**Re: Panda Express at 2040 Gibson Blvd SE (Lot C-2 Lovelace Heights Addition.)  
Erosion and Sediment Control Plan  
Engineer's Stamp date 11/19/2024 (M15E021F) SWQ-2025-00012**

Based on the information in your submittal received on 2/21/25, the above-referenced ESC Plan can't be approved until the following comments are addressed.

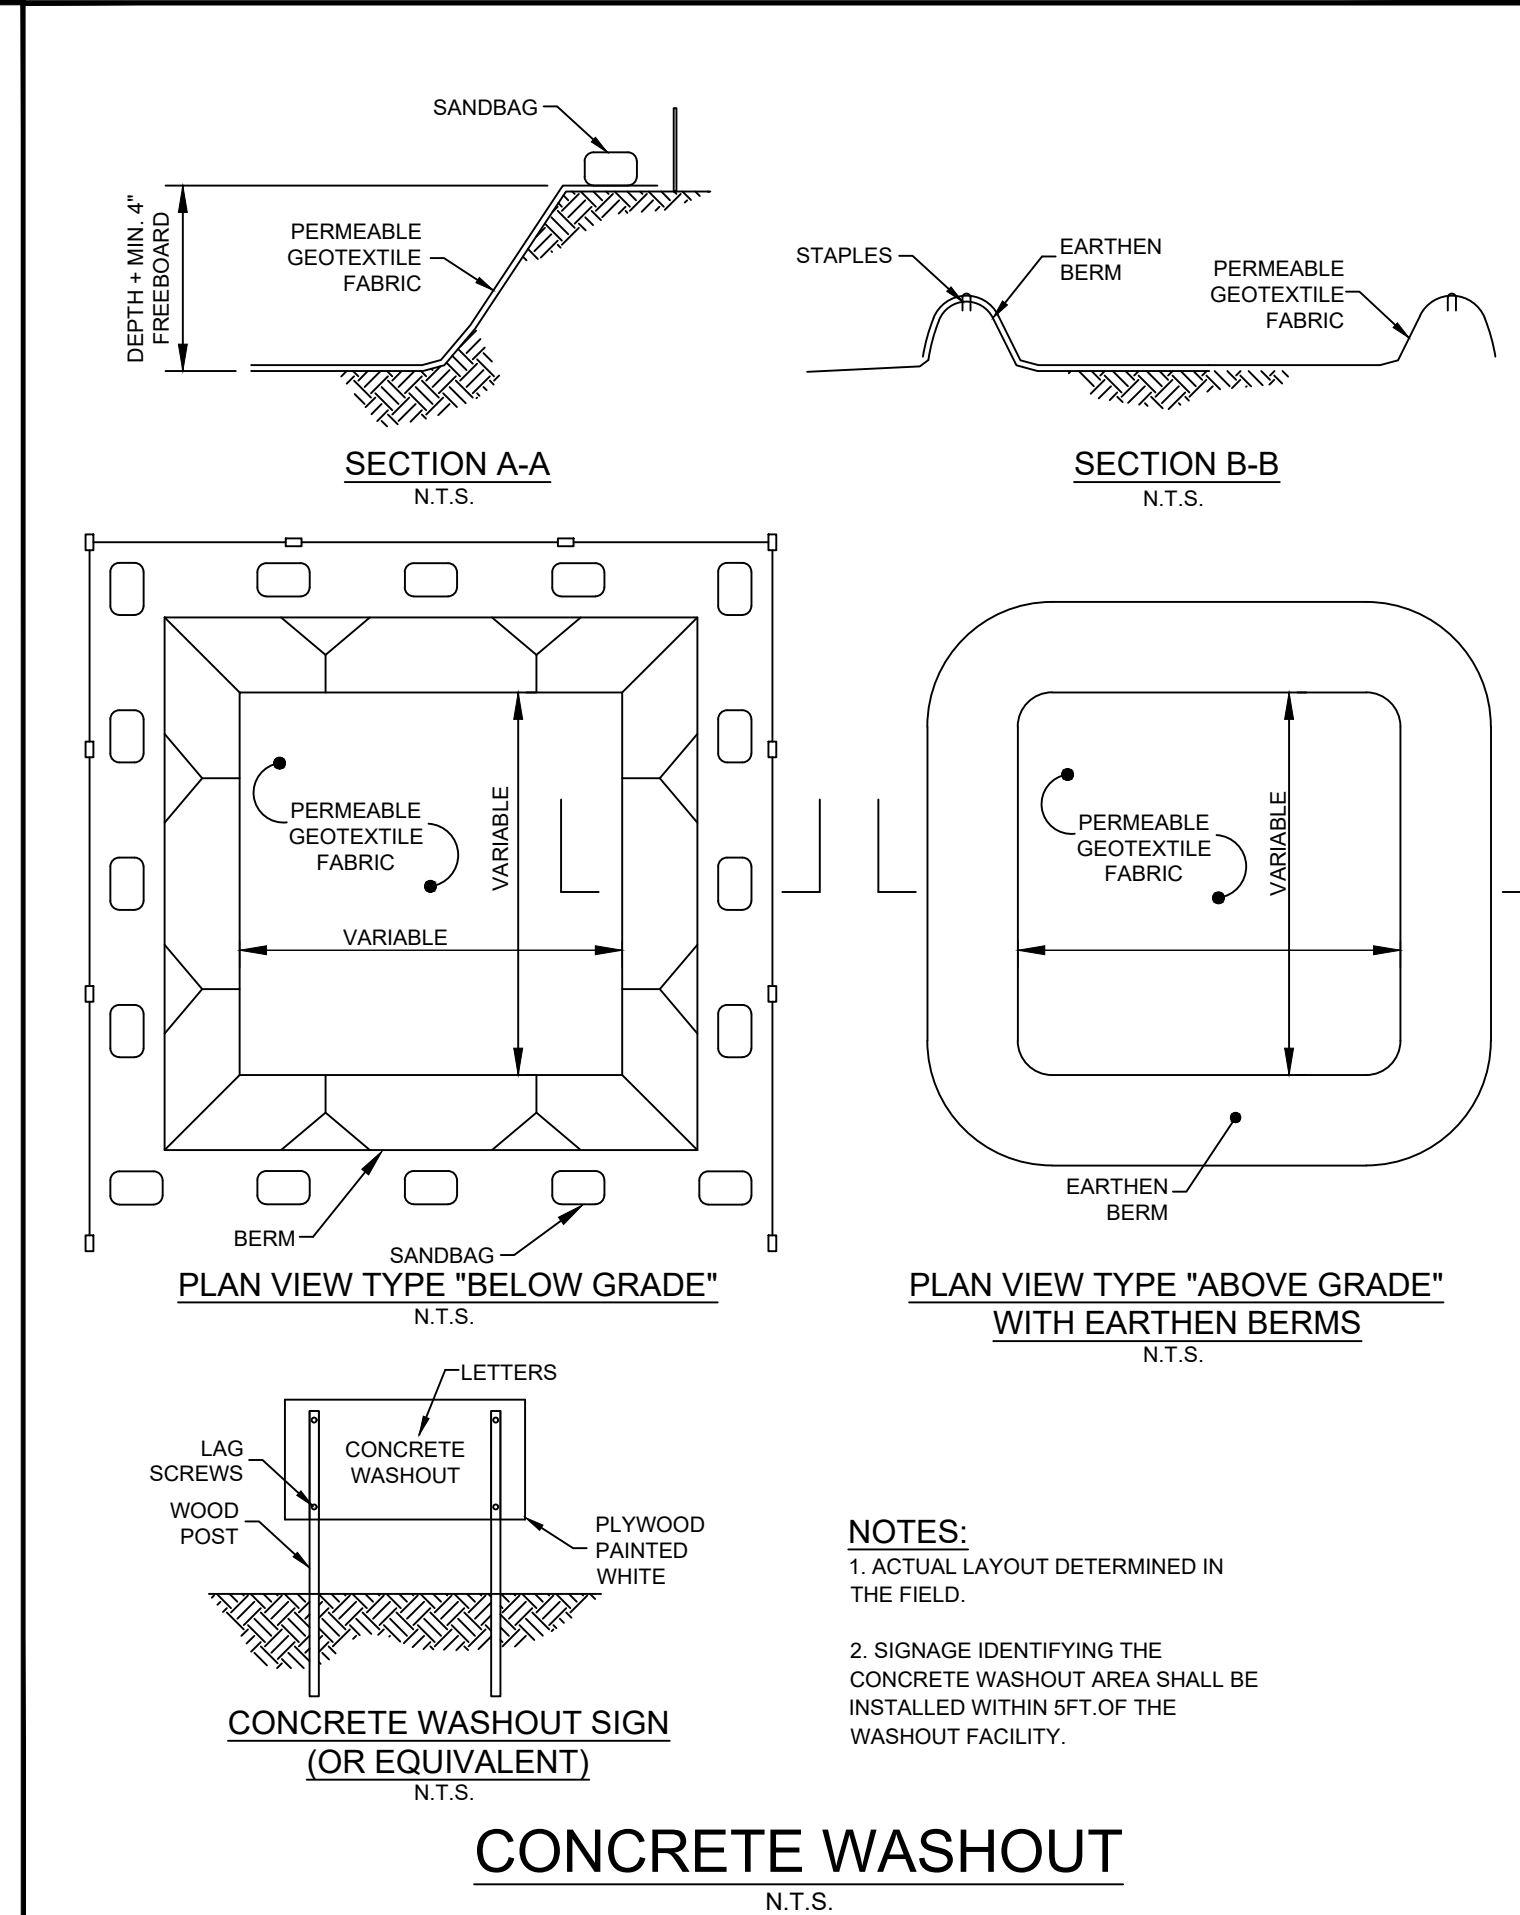
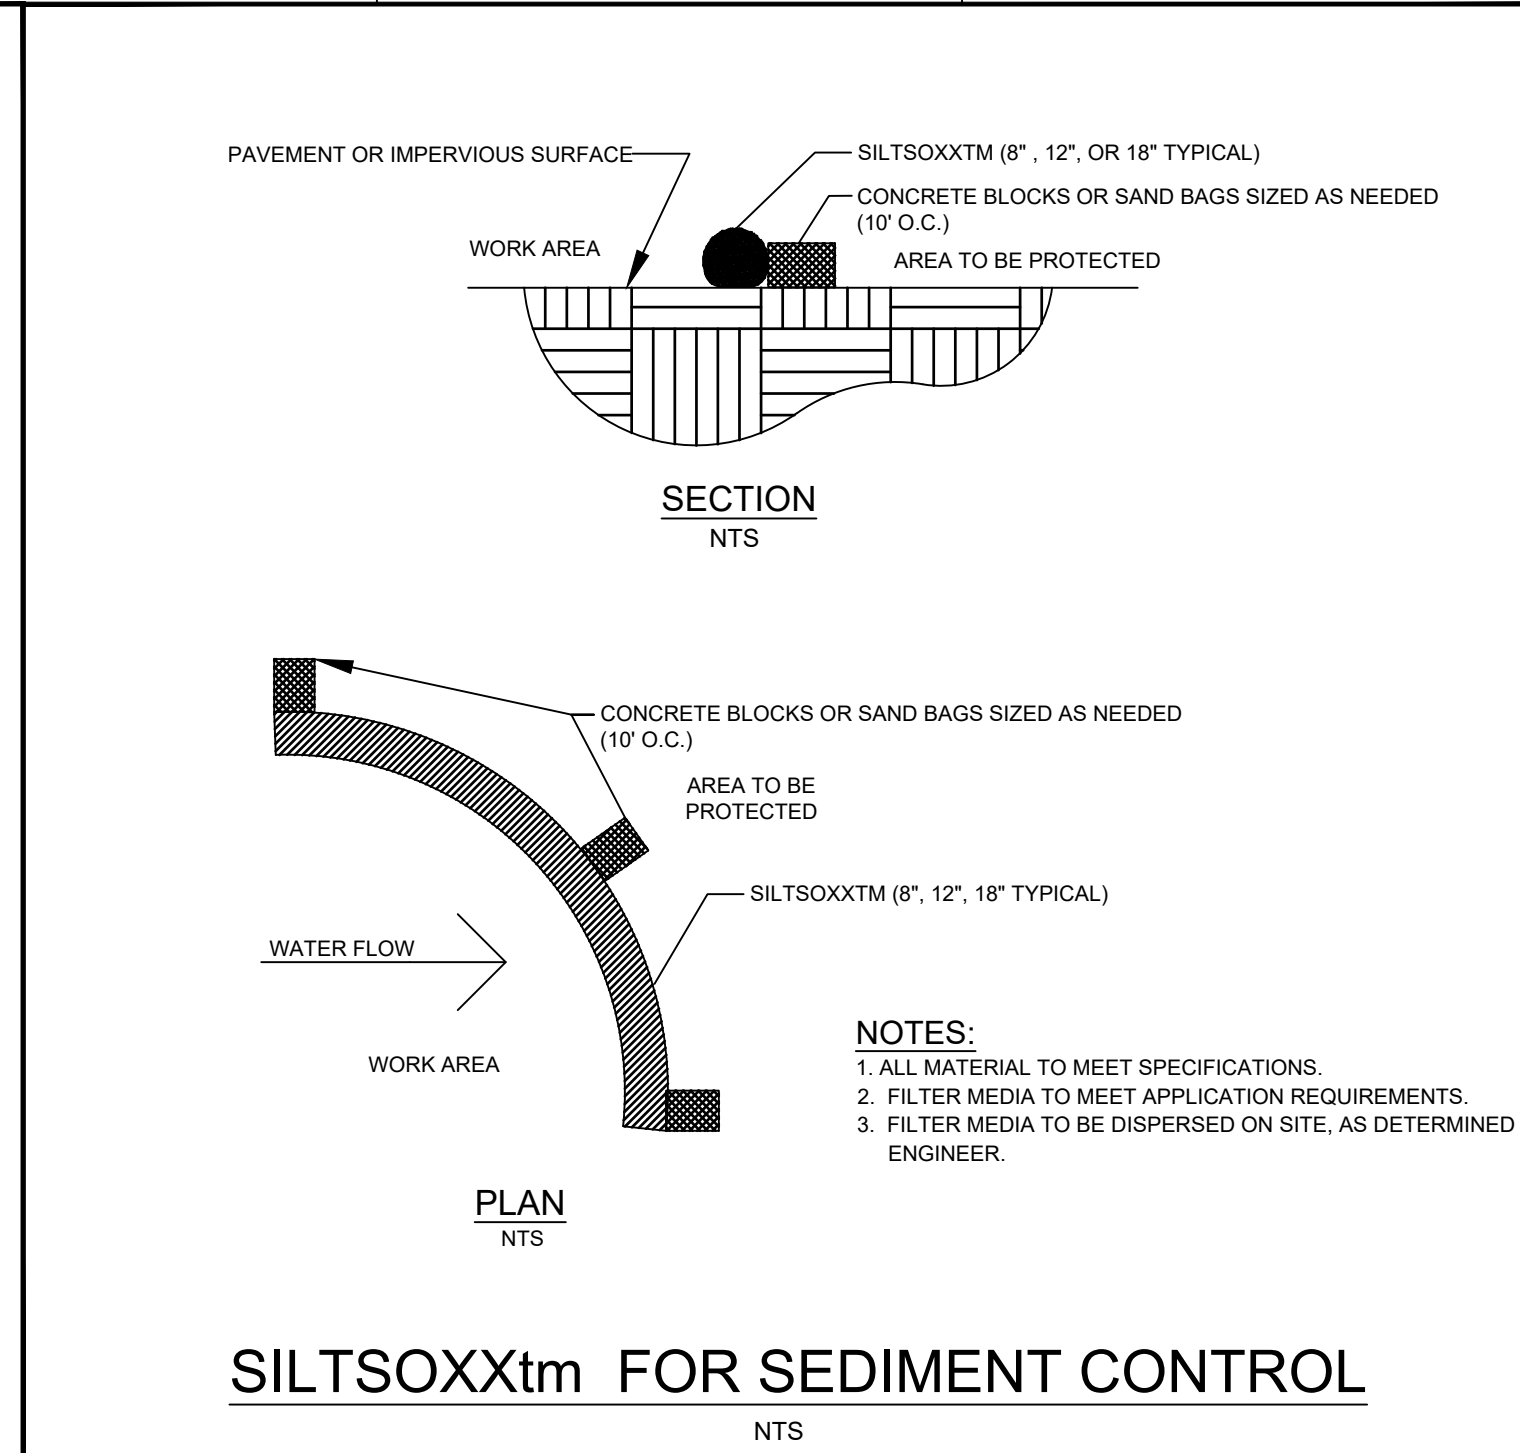
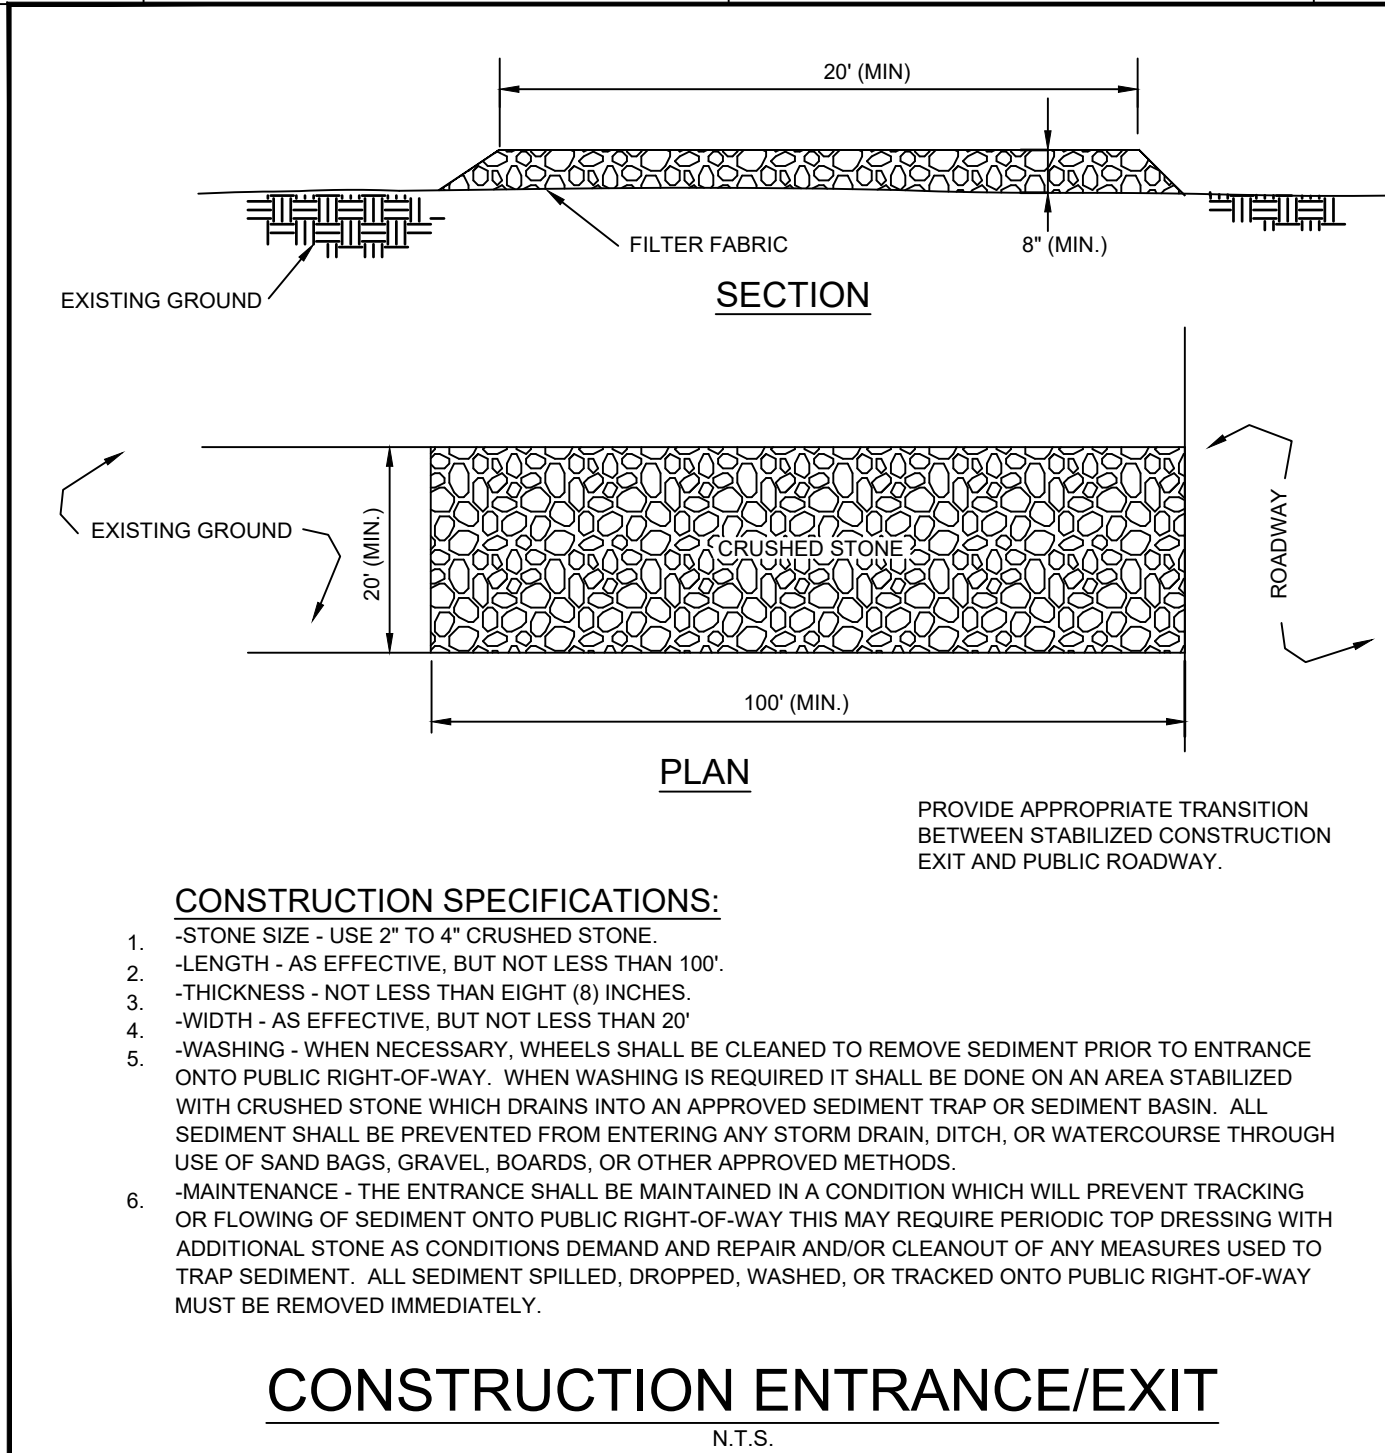
5. The limits of land disturbing activities must include all stockpiles and construction support activities already taking place on the adjacent property, Lot C-1. Also, indicate the areas of control of the two property owners/operators unless all construction support activities are removed from Lot C-1 and the disturbed portions are stabilized with rock per CGP 2.2.14.c.ii before the next City Inspection.

6. The BMPs shown are inadequate. Mulch sock, as shown, isn't an acceptable substitute for Silt Fence. Silt Fence must be shown at the limits of disturbance, including the area of construction support activities and offsite stockpile as a dust control per your Fugitive Dust Permit and CGP 2.2.6. However, Silt Fence alone isn't sufficient to manage the stormwater quality requirements where the silt fence is downhill from disturbed areas, and the Silt Fence isn't located on-contour or the Silt Fence is located at concentrated "Discharge Points." You must identify the Discharge Points on the ESC Plan and add Sediment Traps, one each at the southwest and northwest corners of the site. At all locations downhill from disturbed portions of the site where the Silt Fence isn't on contour, you must add Diversion Berms in addition to the Silt Fence.

8. Describe the nature and extent of construction activities (CGP 7.2.2.) on the ESC Plan. Include the size of the property and the size of the area of land-disturbing activities onsite and offsite. Describe construction support activities and show the staging area on the ESC Plan. Describe the construction sequence, with the placement and removal of the required stormwater controls being the first and last items of construction. Resolve the discrepancy between the controls described in Section 2 of the SWPPP and what is specified in the ESC Plan and add the description and details to the ESC Plan.
